# Rezoning Transportation Analysis

Petition Number: #2022-084

## Revision Log:

Date	Description
11-28-22	First Review (TM)
12-15-22	Second Review (DR)
02-22-23	Third Review (TM)

**SCHEMATIC**  
**SITE PLAN**

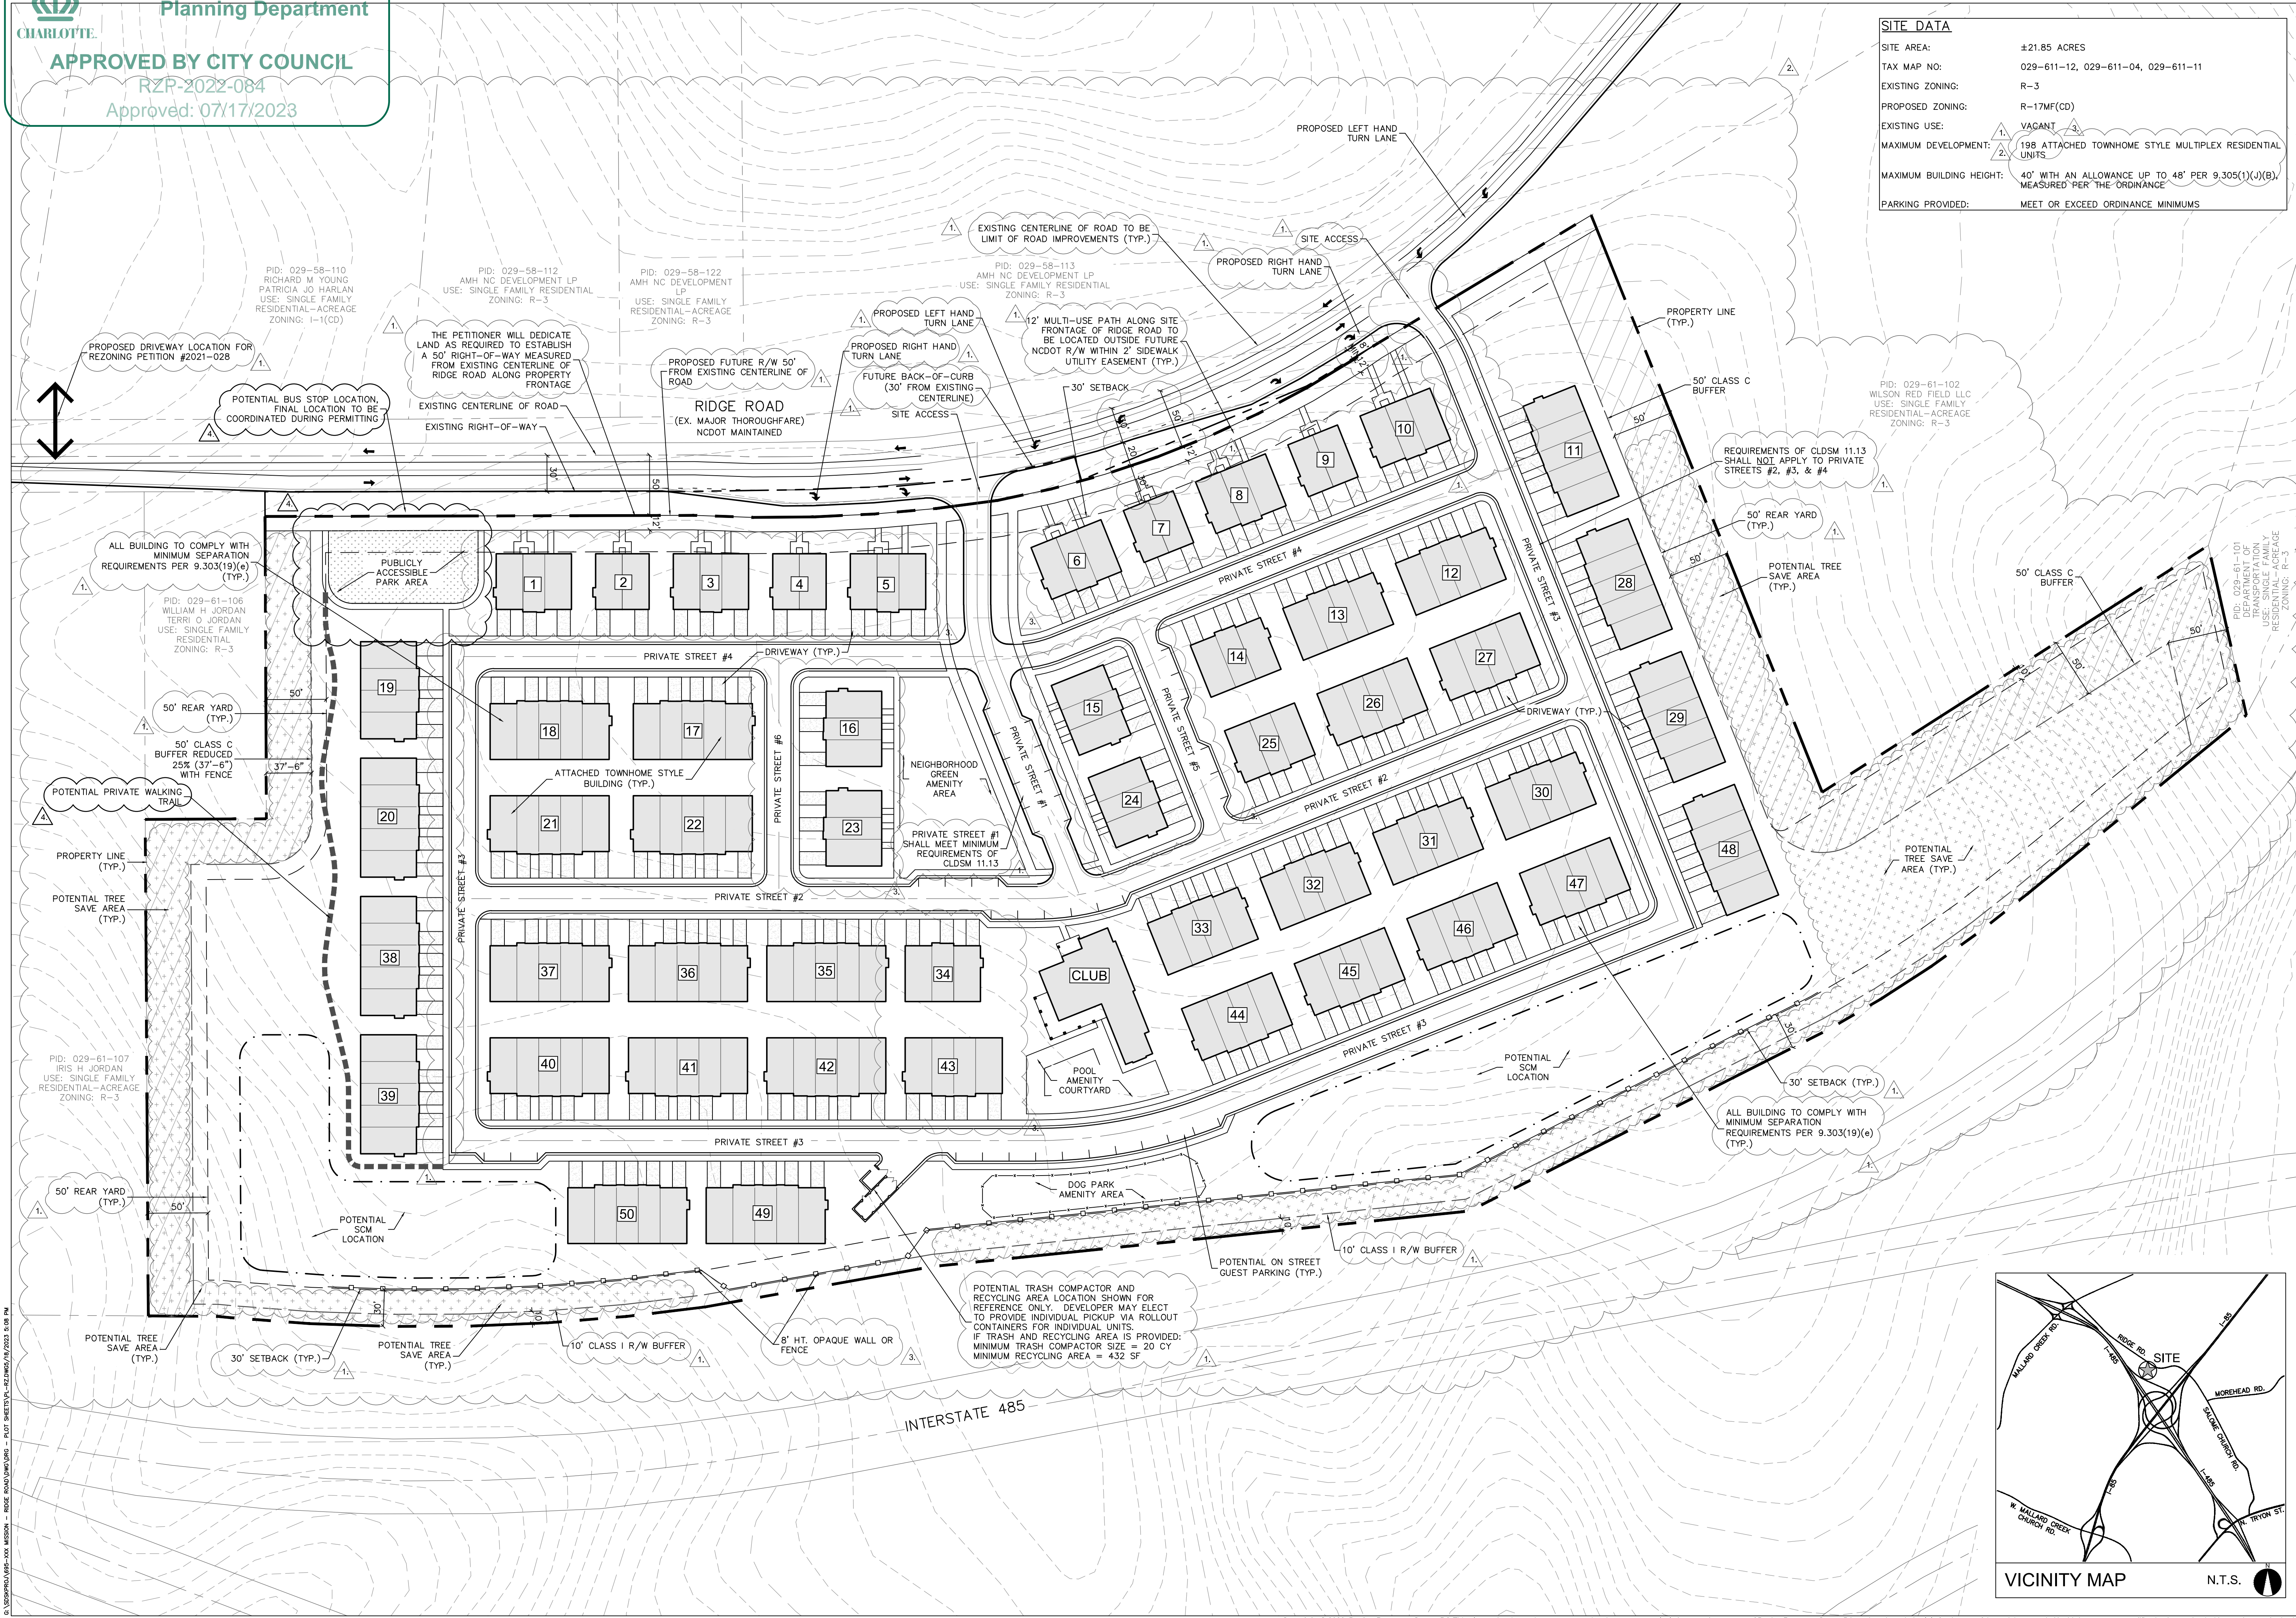
- ~~**Curbline:** The proposed zoning district has a setback measured from back of the existing or proposed future curbline.~~
  - ~~**Ridge Road:** The future location of curb and gutter is measured at 30 feet from the centerline of the roadway to the BOC.~~

~~Label and dimension the curb and gutter from the centerline for each road on the site plan.~~

- ~~Revise site plan and conditional note(s) to commit to dedicate 50 feet of right-of-way from the road centerline. The site plan shall label and dimension the right-of-way from the road centerline.~~
- ~~Site plan and conditional note(s) revisions are needed to commit to constructing internal private roads to meet or exceed CLDSM standard 11.13. Site plan shall callout CLDSM 11.13 and add roadway cross section detail.~~

5. ~~Site plan and conditional note(s) revisions are needed to commit to constructing a full three lane section on Ridge Road along the site frontage. 3 lane section to include a two-way left turn lane along the site frontage and two through lanes. Dimension the transition length and width of the two-way left turn lane along Ridge Road per NCDOT comments.~~

6. ~~Site plan and conditional note(s) revisions are needed to commit to constructing a right turn at both driveways per NCDOT comments.~~
7. ~~Site plan and conditional note(s) revisions are needed to commit to aligning site entrances with the Kings Grant rezoning (2021-028). Site plan shall show linework from Kings Grant development along Ridge Road. **Comment Rescinded 12-22-22**~~

11. ~~Revise site plan to construct a 12-foot multi-use path on Ridge Road. The site plan shall label and dimension both items from the back of curb and gutter and road centerline. The entire facility must be outside of the right of way and within a public access easement. Add conditional note committing to construction and maintenance of the 12-foot multi-use path on Ridge Road.~~
